Retrospective application for dormer and front elevation weatherboard clad.

21 Hawke Close Rustington

Thank you for your internet representation made on 1st August 2014 which has been recorded as '**an objection**' with the comments as follows:

Proposed Front Elevation. Scale 1:100

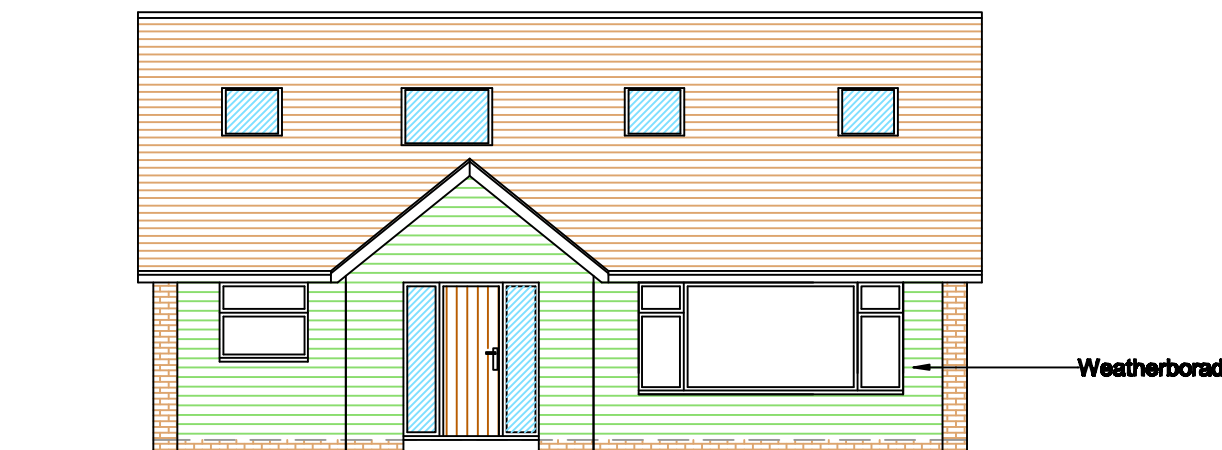
We are of the opinion that the proposed weather-boarding is completely unsuitable for, and out of character with this locality. To the best of our knowledge there are no other properties in the immediate vicinity (Hawke Close, Jervis Avenue, Ruston Park etc) that have such boarding to their frontal elevations - predominantly they are all showing some mix of brick, tiles or render. We feel that the proposed weather-boarding is not appropriate for properties that, generally, were built in the 1960's or earlier, and should be only be applied to more modern buildings.
